Town & Country Planning Act 1990 (as amended)
Town and Country Planning (Development Management Procedure) (England) Order 2015
Approval of details reserved by condition imposed under ref APP/C3810/W/19/3241407 (AL/62/19/PL)
relating to Condition Nos 3 - surface water drainage and 4 - protection of retained trees & boundary
vegetation.
Land to South of Sundown Littleheath Road Aldingbourne BN18 0SR

Condition Number 4

Arun District Council have decided to **REFUSE details reserved by condition for the following reasons:**

PROJECT AND DRAWING NO.
17-1197 — DR 501

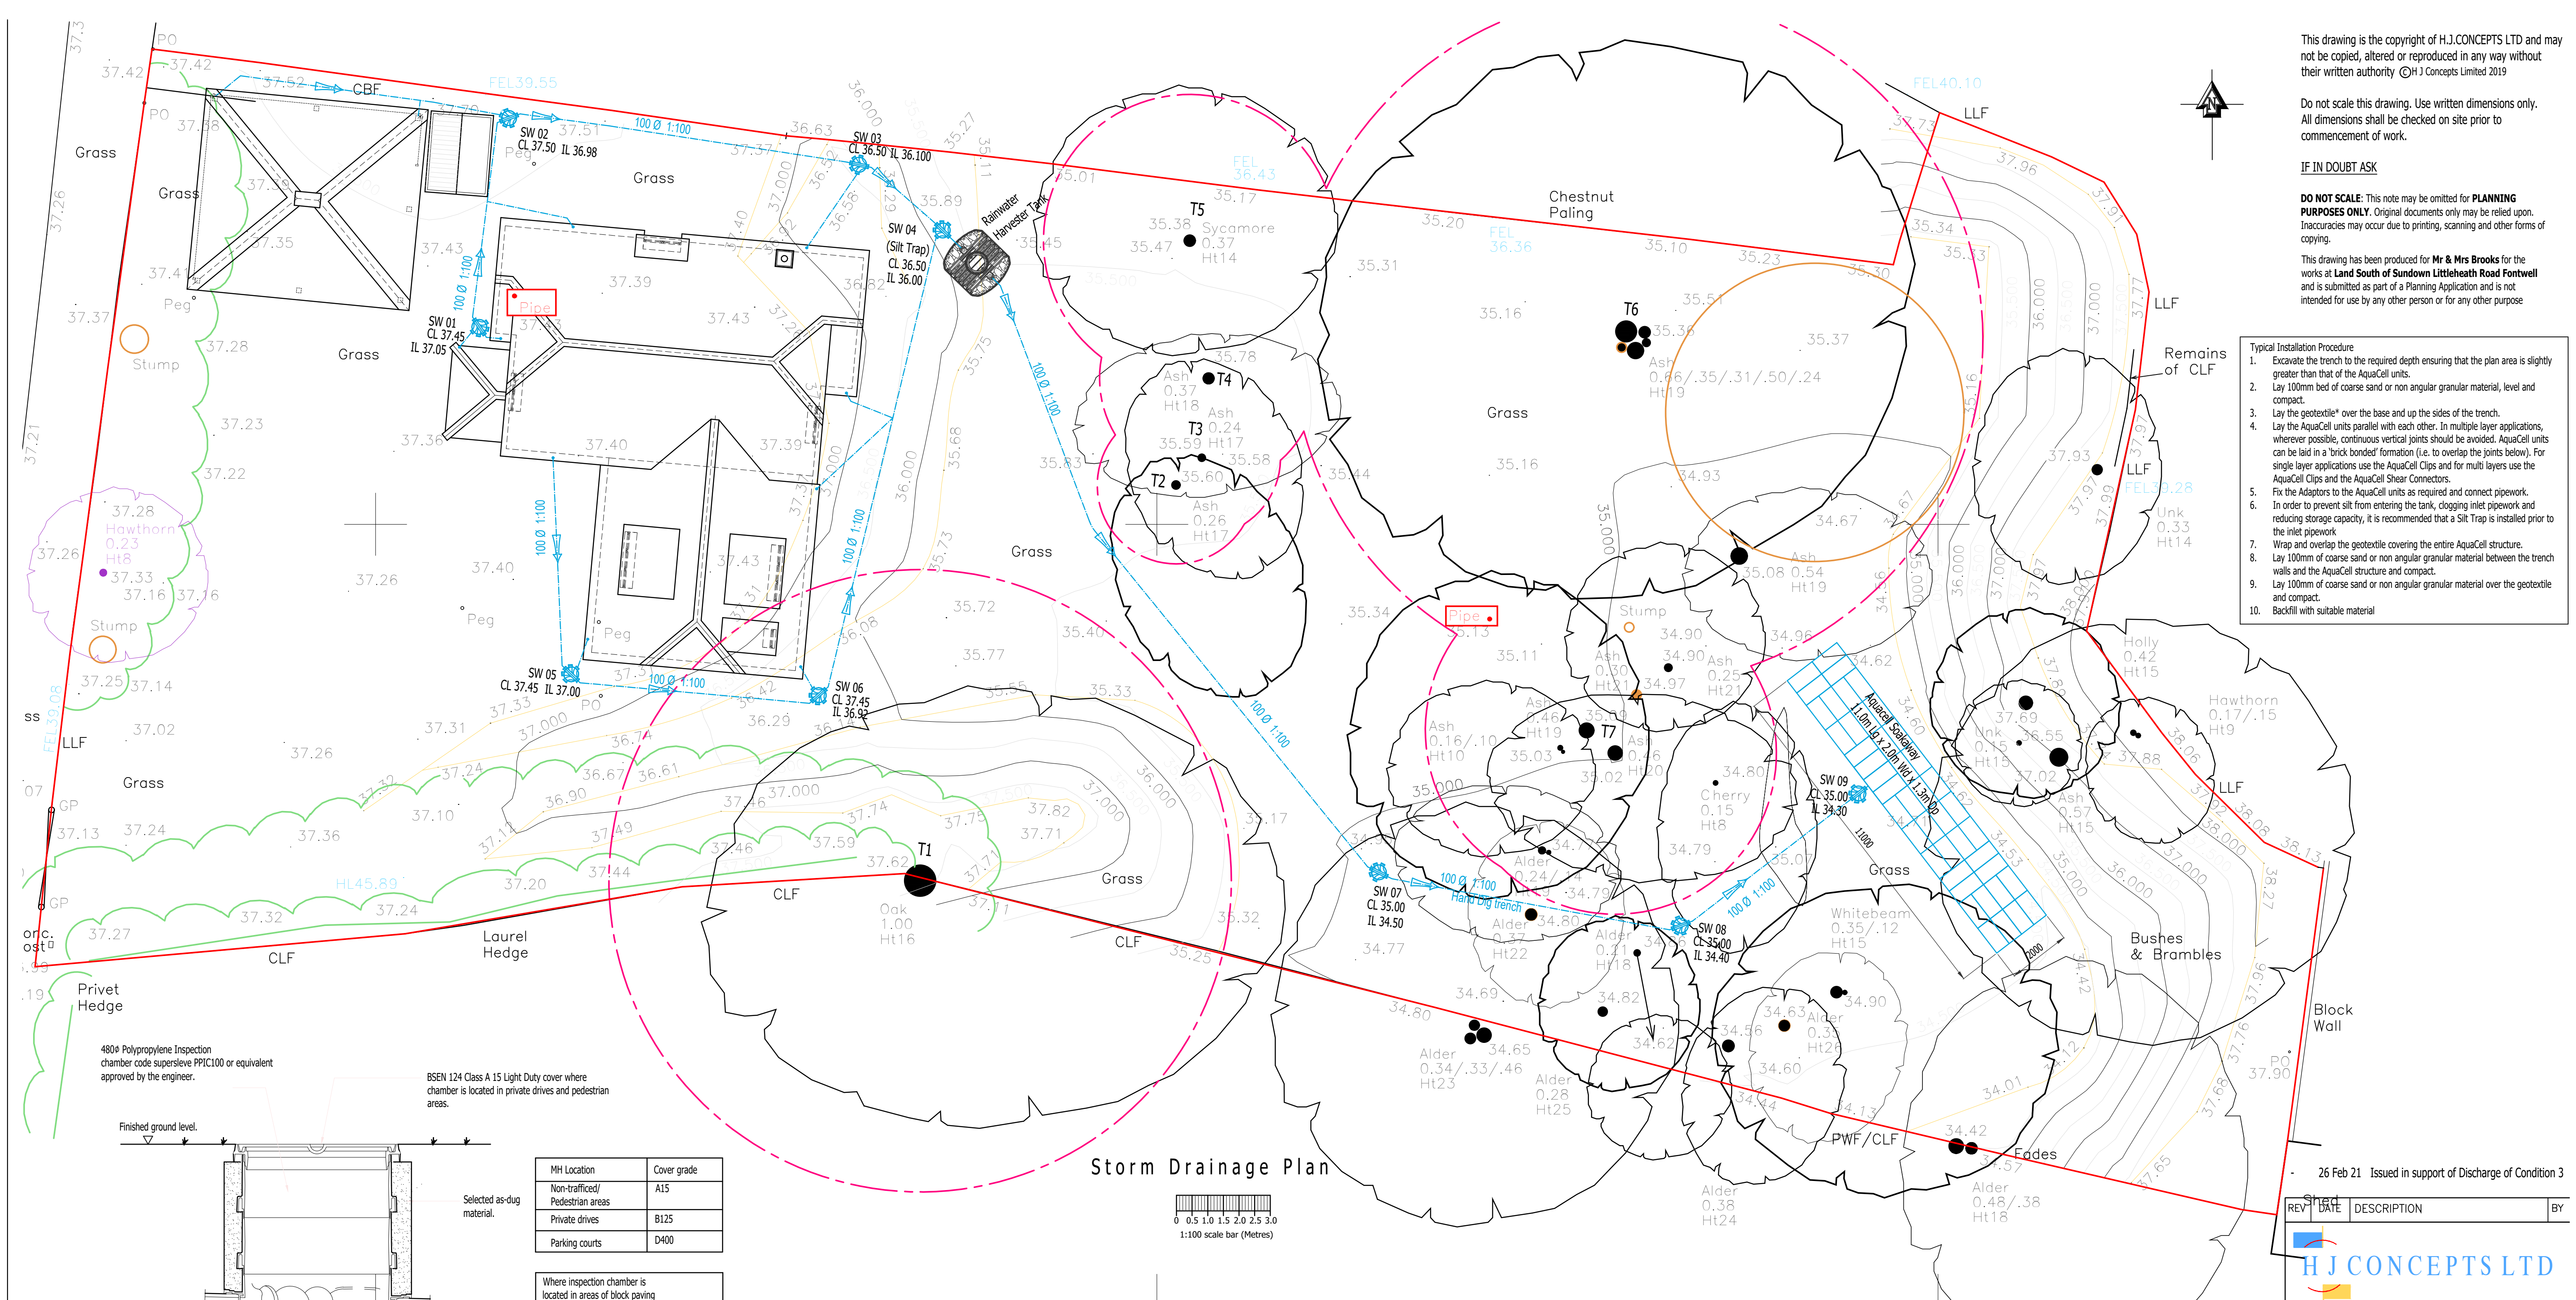
Arun Drainage Engineers in their comments point out the arboricultural report, particularly paragraph 11.2 stating that a construction exclusion barrier will be in place for the protection of trees in the eastern part of the site. The area is to be 'afforded protection at all times during development process; strictly no access, construction activities, mixing materials or storage will be allowed.' Yet the surface water drainage design routes pipes through the area and sites a significant soakaway within the area. The Alder shown on the Drainage Layout appears to be being retained (as it is not located within the site), as such the roots of this tree should be considered in the drainage design. At present the surface

water drainage design appears to be in direct conflict with the arboricultural report.

For the above reason condition 4 cannot be discharged and you will need to make a revised submission.
